Application No: FG/46/20/PL
Site Address: The Tudor Close Public House Ferringham Lane Ferring BN12 5NQ
Description of works: Conversion of the existing Public House (Class A4) to create 7 No residential units comprising 5 No 1-bedroom units & 2 No 2-bedroom units & the erection of 2 No 2-bedroom semi-detached chalet bungalows with associated car parking & landscaping. This application may affect a Public Right of Way.

Thank you for your internet representation made on 20th May 2020 which has been recorded as an objection with the comments as follows:

Drawing Title:
Elevations
As Proposed

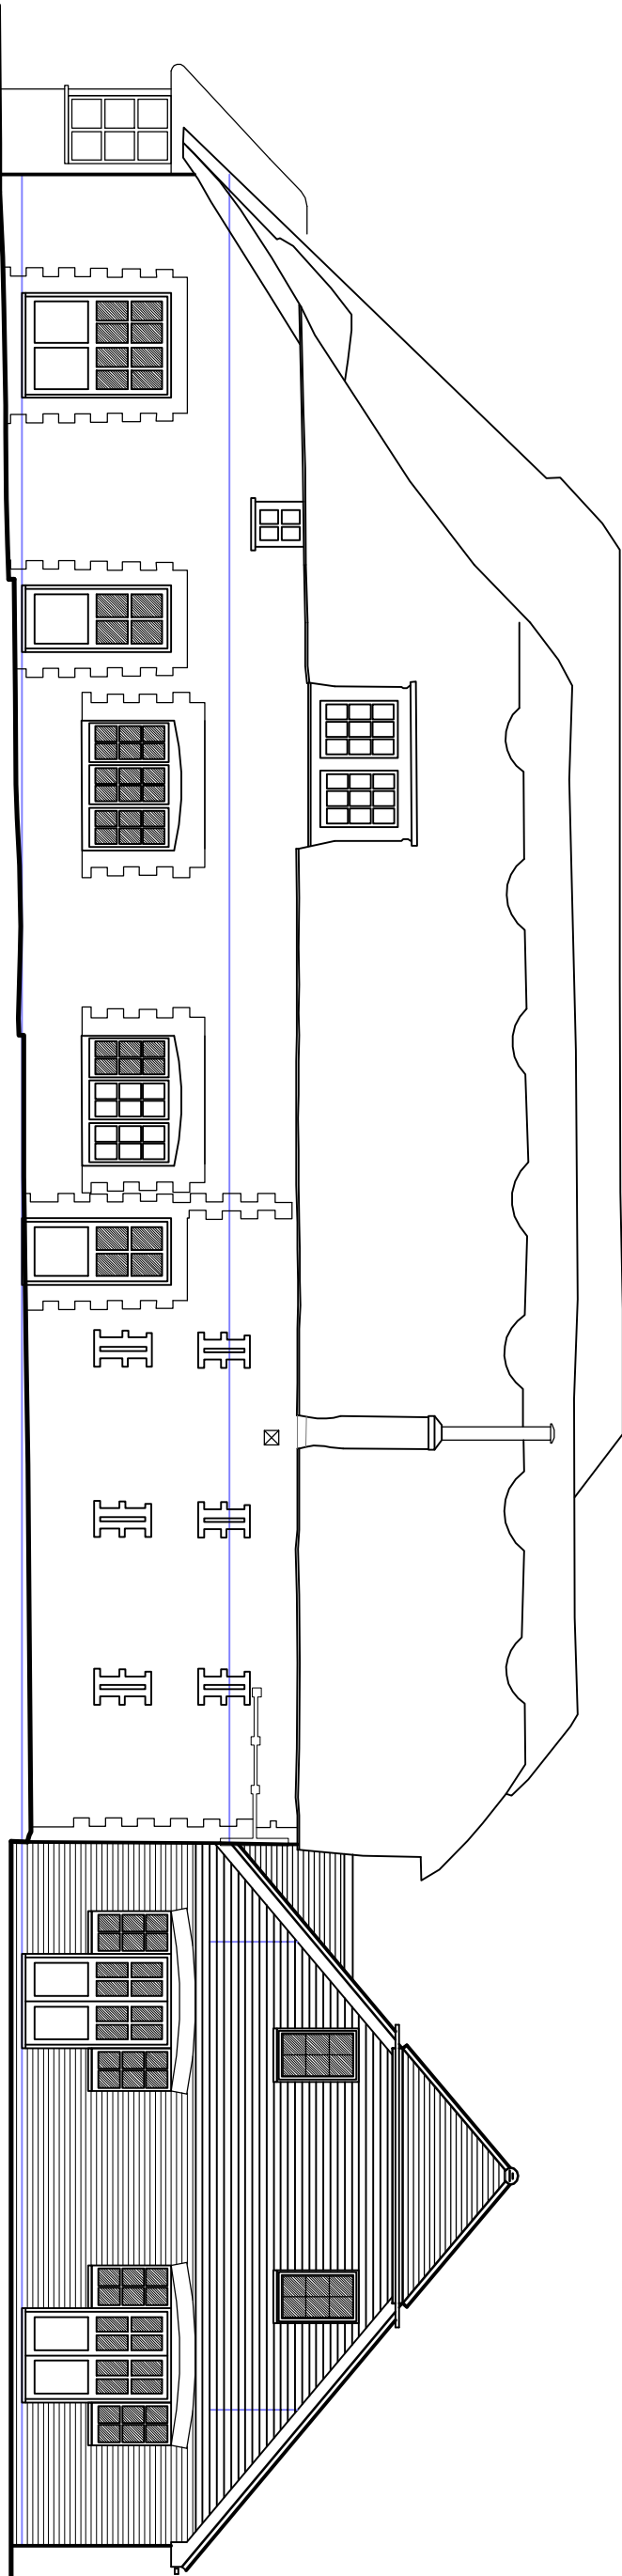
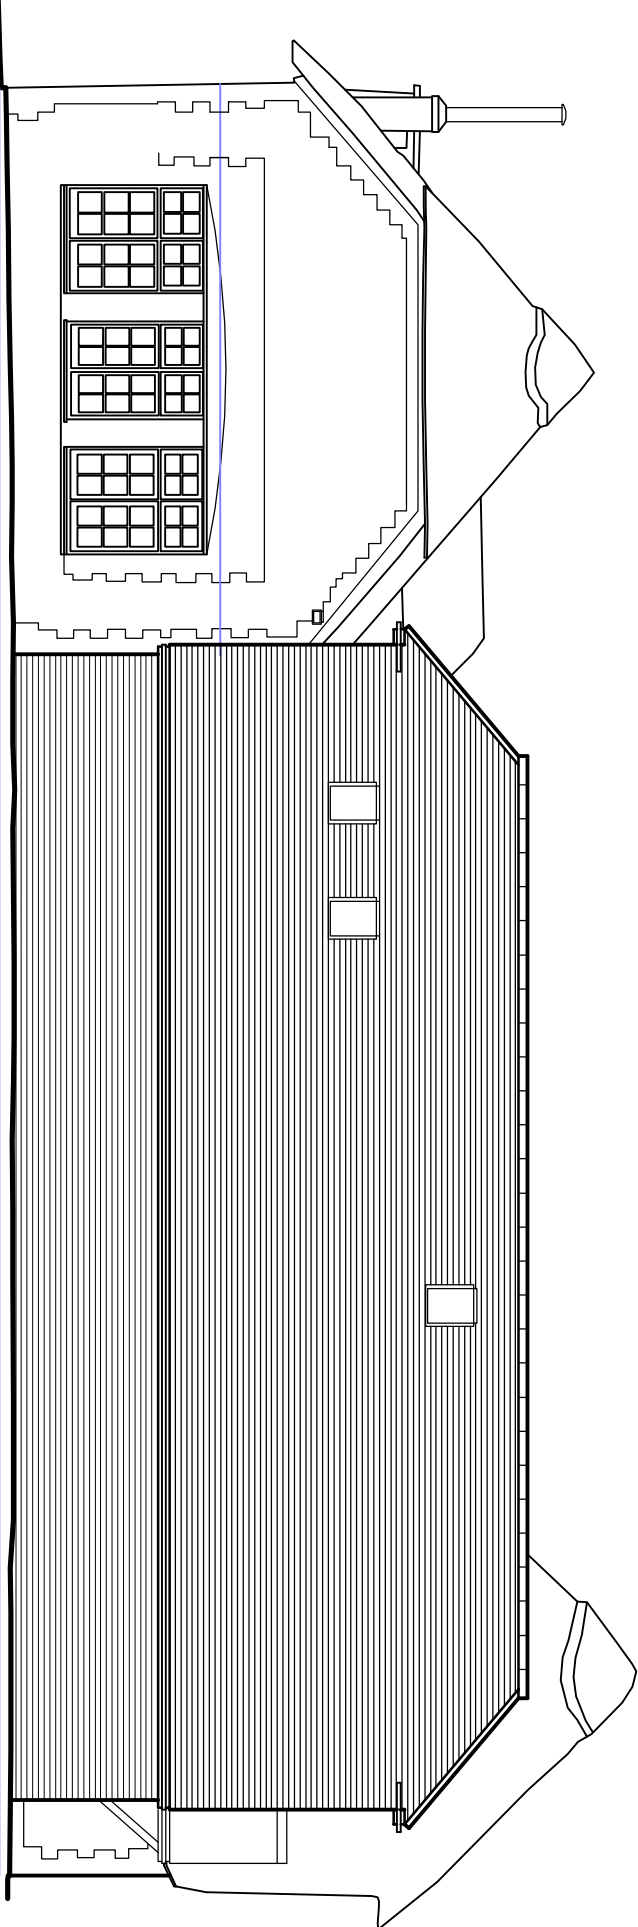
From the details submitted with the application I would suggest that by constructing an extension to the South Elevation to accommodate 2 no units with no consideration given to the Architectural features, or materials used to preserve and enhance the existing Building. In assessing this development's compliance with the Local Plan requirements to protect and enhance Architectural features and ensure the protection of these such Buildings. I would suggest this application does not meet that requirement.

The proposed extension of the Building to the South adjacent to Garden Park Constitutes over development of the site and is not appropriate in this location as the massing and scale of the proposal is not in line with the existing development and would result in what appears to be an unimaginative infill taken almost to the boundary with no thought to the neighbouring land or properties. This area would be better and more appropriately used as garden ground or amenity for the 7 units proposed within the existing Building.

Drawing Title:
Landscape Plan
Block Plan
As Proposed

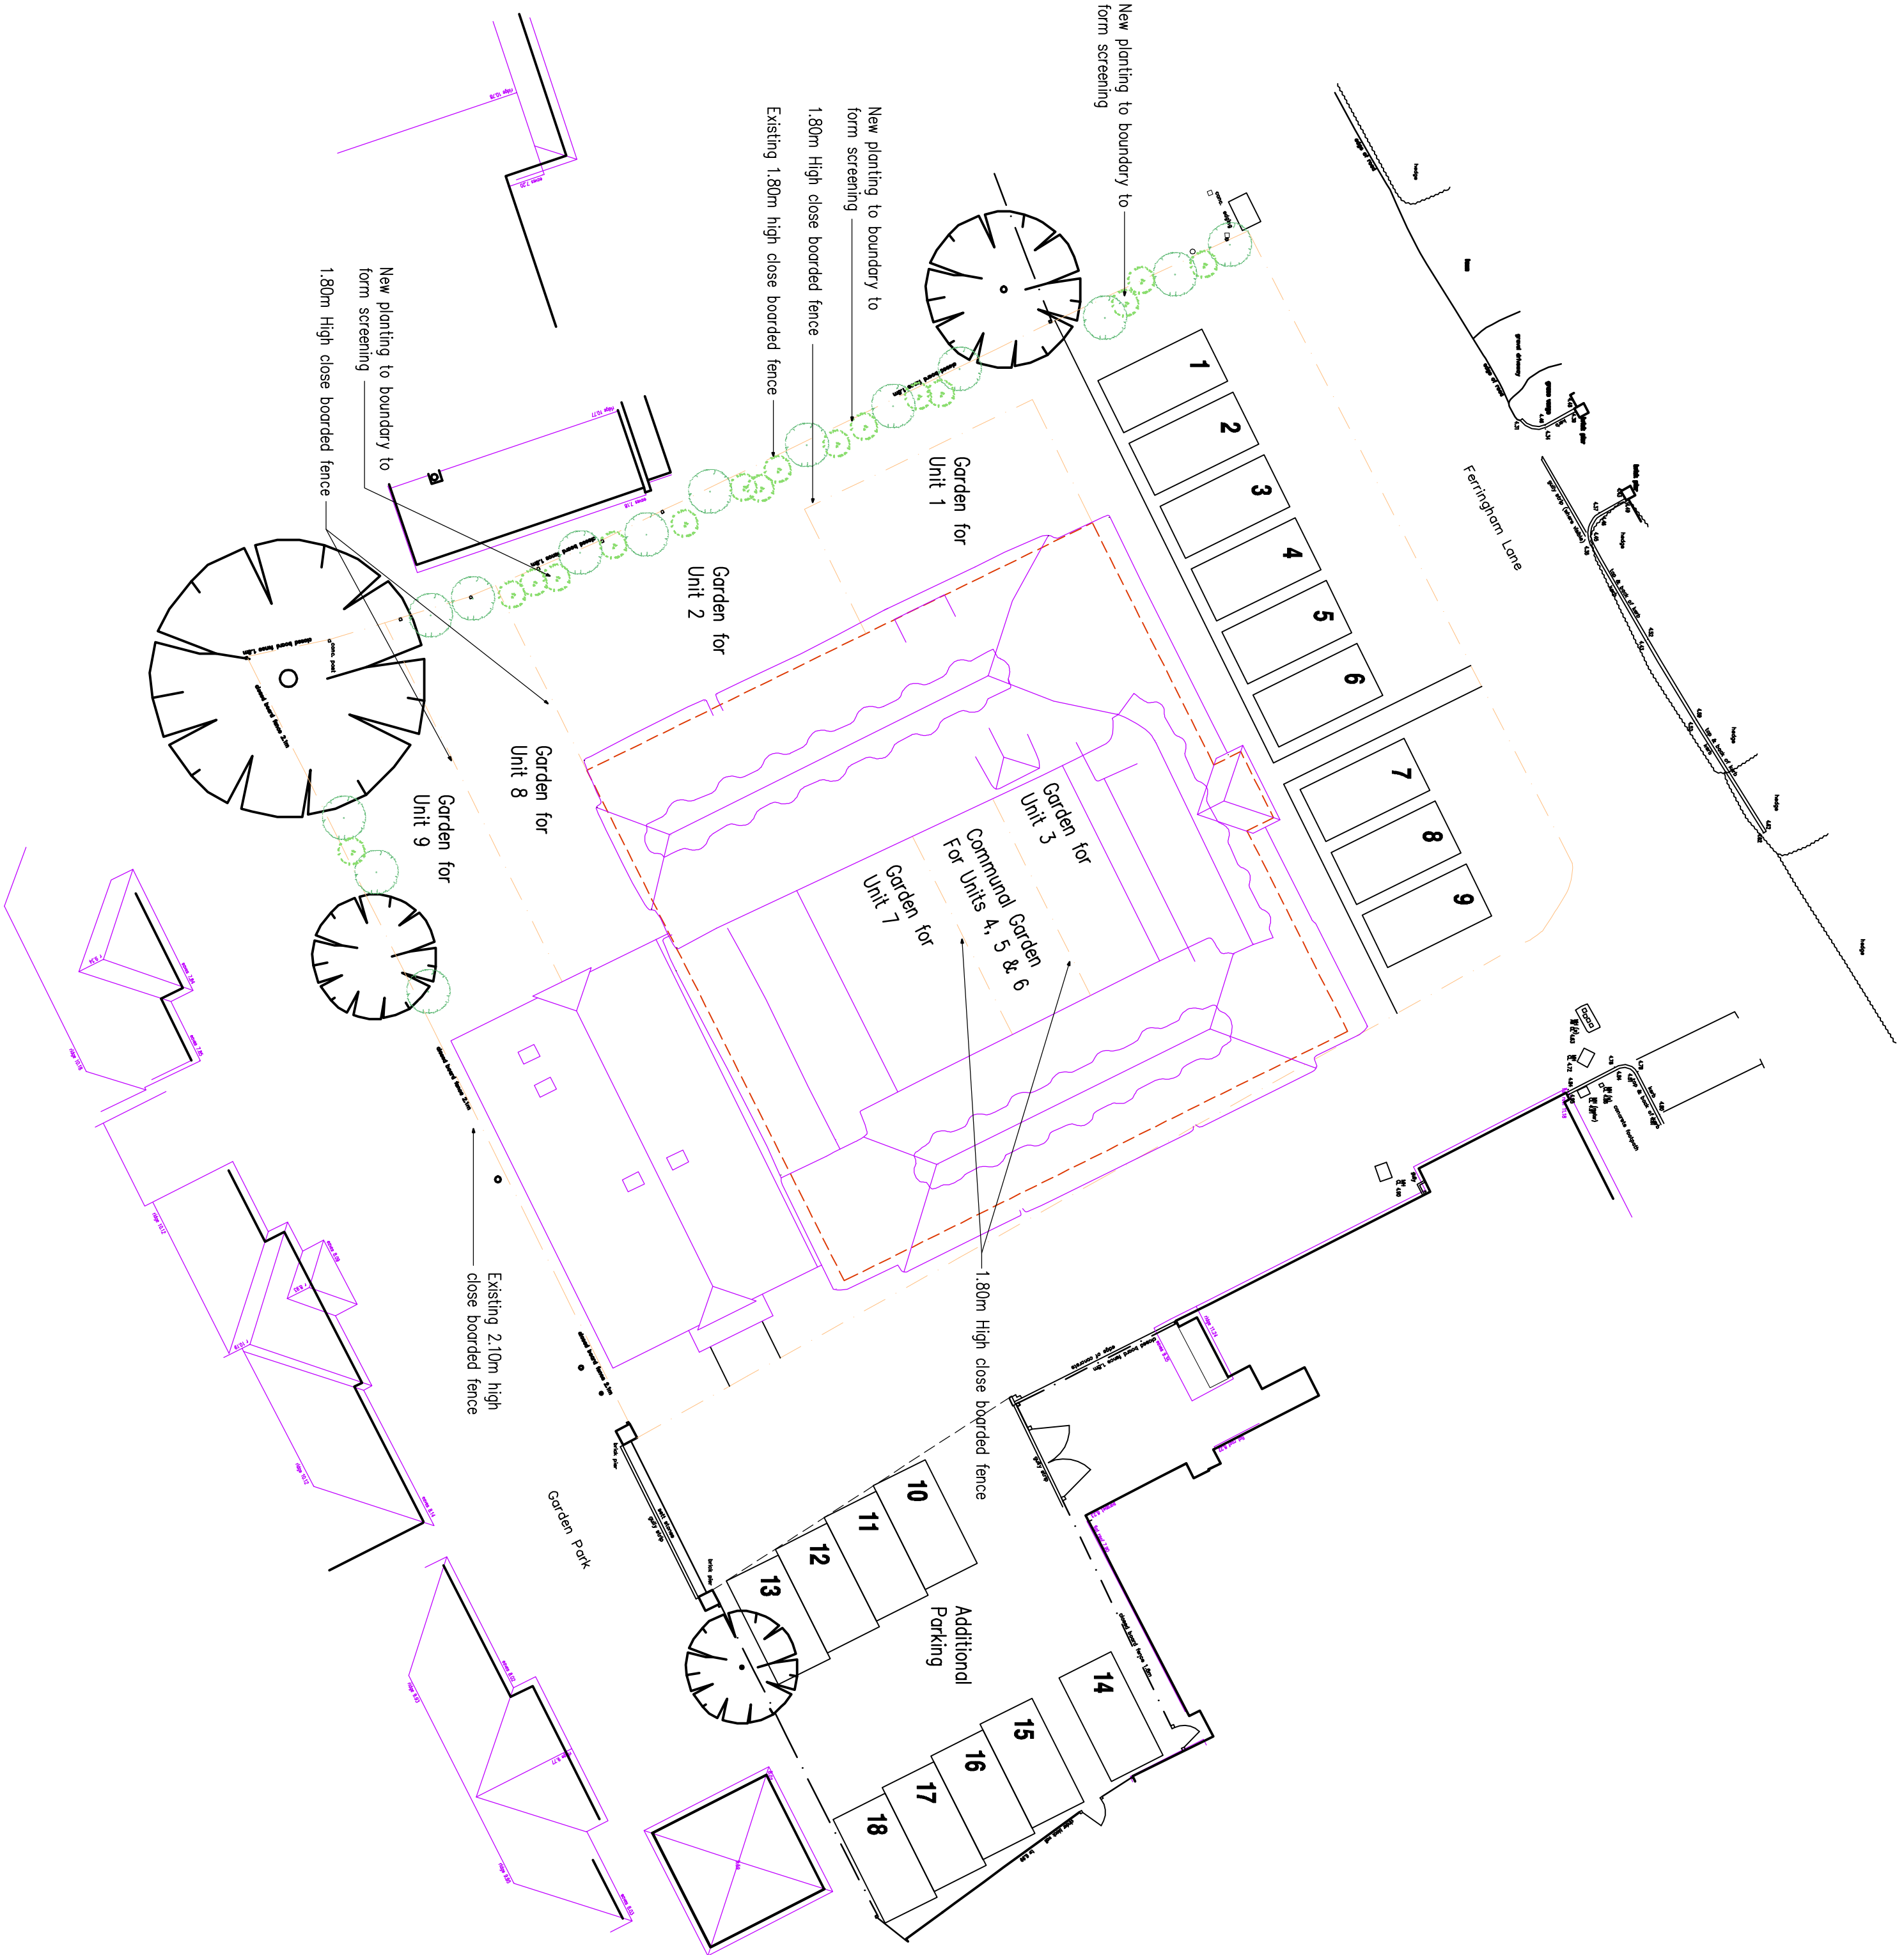
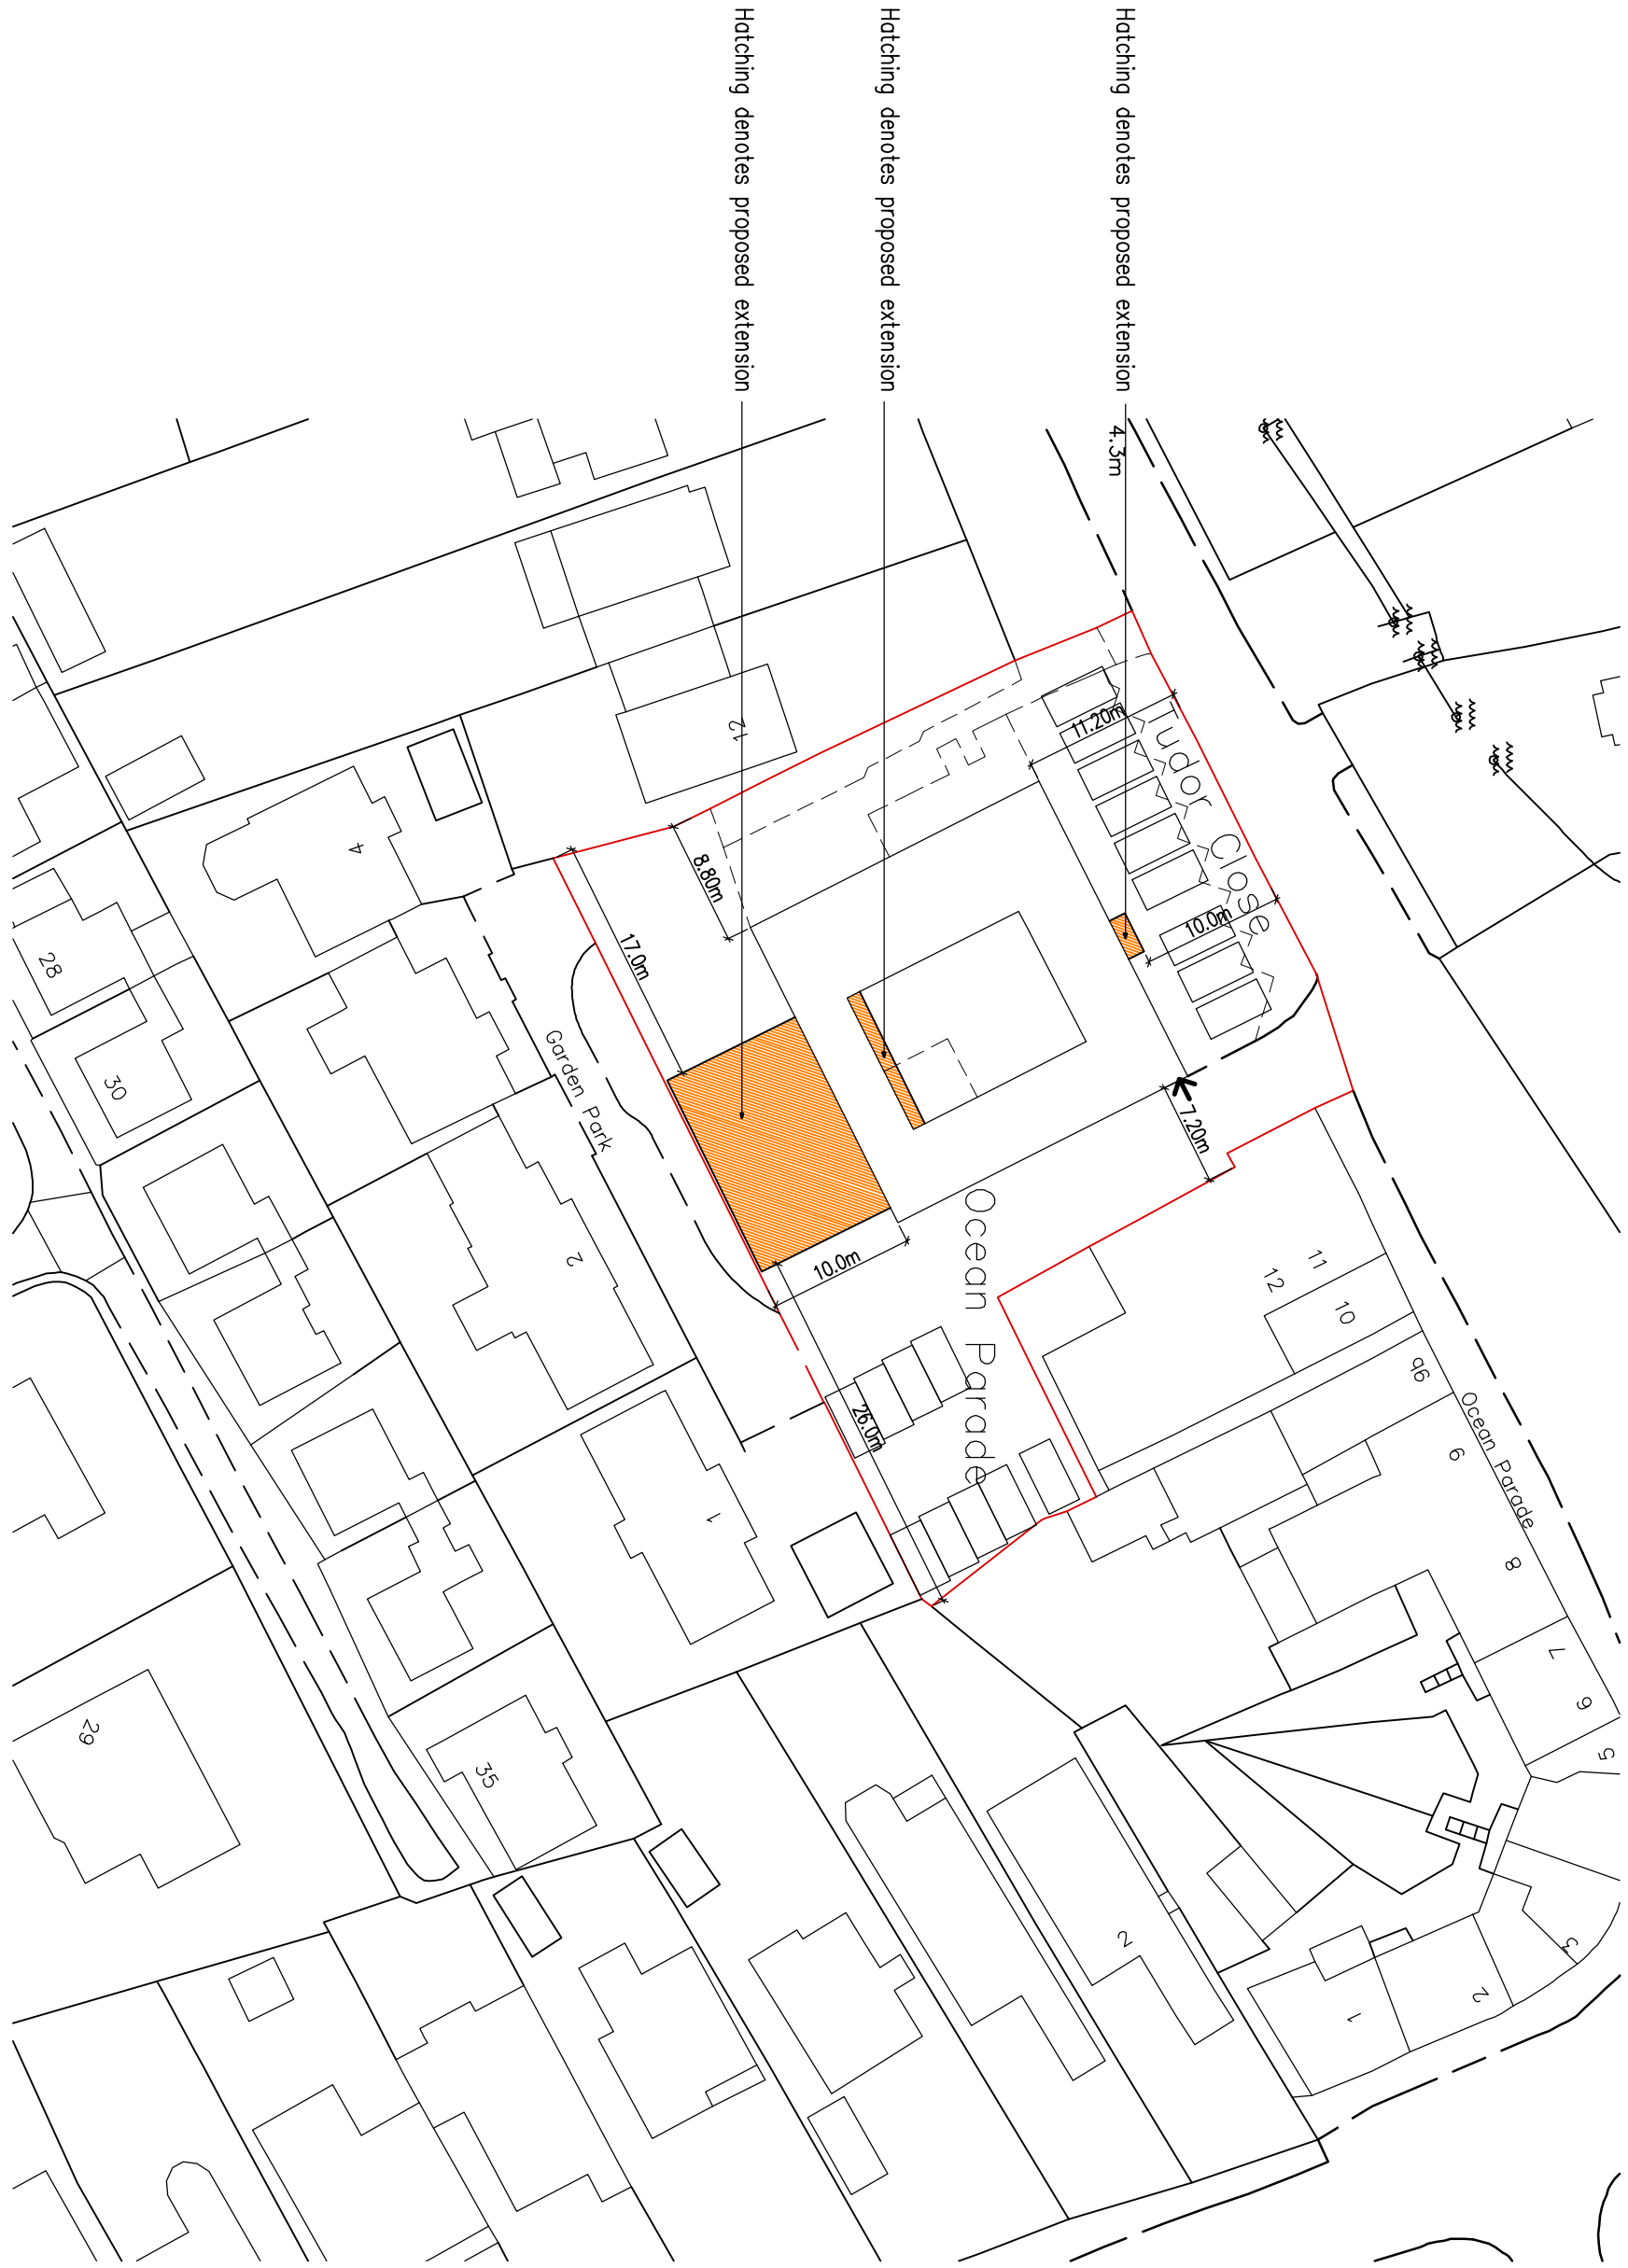
Should consideration to approving any such extension it should be conditioned to ensure appropriate materials etc are used and the scale of the proposal is in accordance with the suitable space available and that provision is made to protect the boundary fence line and trees which are out with the application site but would be adversely effected but a development in such close proximity to the boundary.
